**From:** TownPlanning LNW <TownPlanningLNW@networkrail.co.uk>  
**Sent:** 07 December 2020 12:49  
**To:** Planning  
**Subject:** Ribble Valley ref 3-2020-1038 9 Fox St Clitheroe DofC boundary-ground levels  
HOLDING OBJECTION  
**Attachments:** dev Asset-Protection-Initial-Enquiry-Questionnaire-Rev-1.1.docx  
**Categories:** Blue Category

3/2020/1038

Discharge of Conditions of planning application 3/2014/0776. Condition 3 - Materials, 4 - Boundary Treatments, 7 - Construction Method, 8 - Drainage, 9 - Ground Levels.  
9 Fox Street Clitheroe Lancashire BB7 2AQ

FIGURE 4

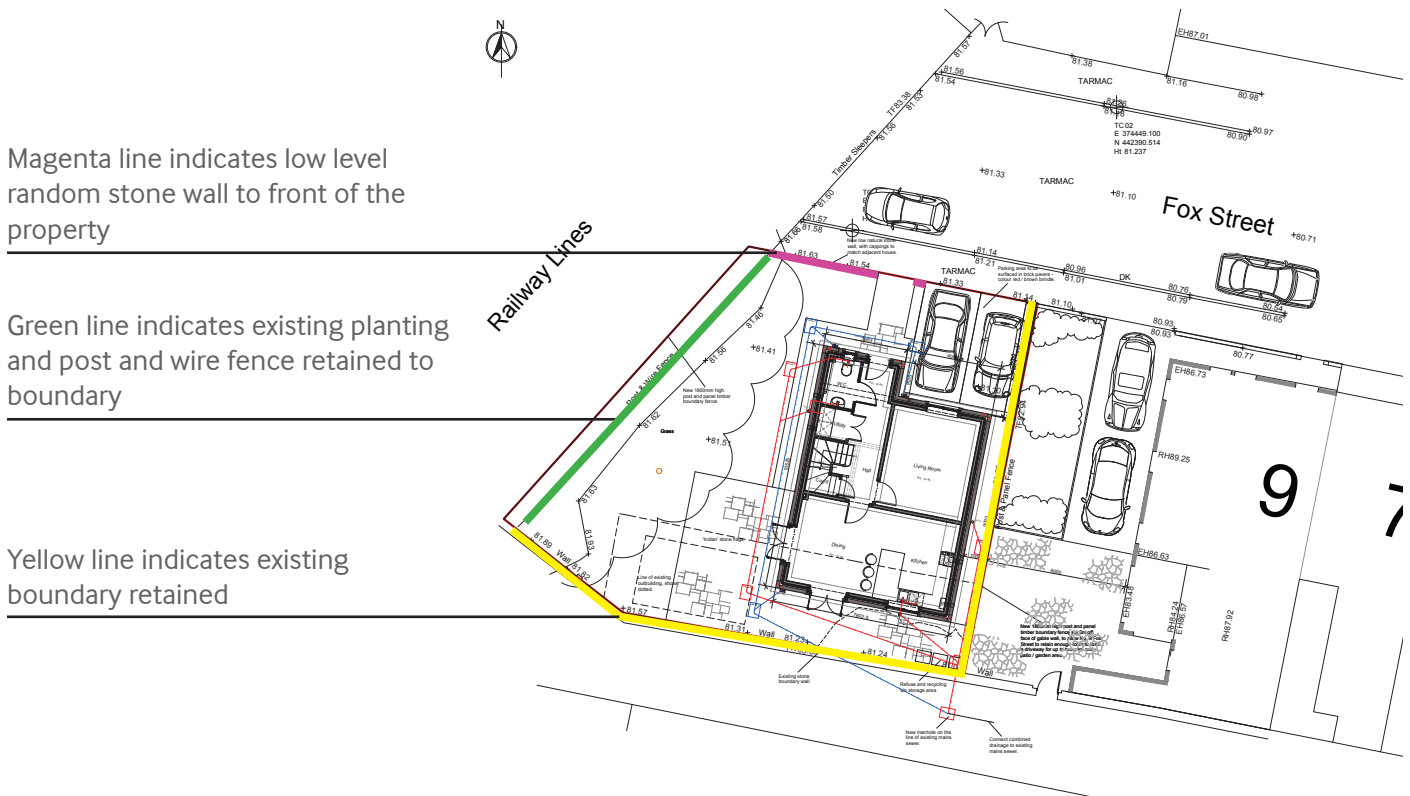
The site plan appears to show a "New 1800mm high post and panel timber boundary fence" which appears to be on the railway boundary. This is not acceptable to Network Rail. Any outside party fencing must be set back at least 1m from the railway boundary to ensure that NR's boundary treatments can be maintained and renewed as well as ensuring that there is no impact to any cabling on our land.
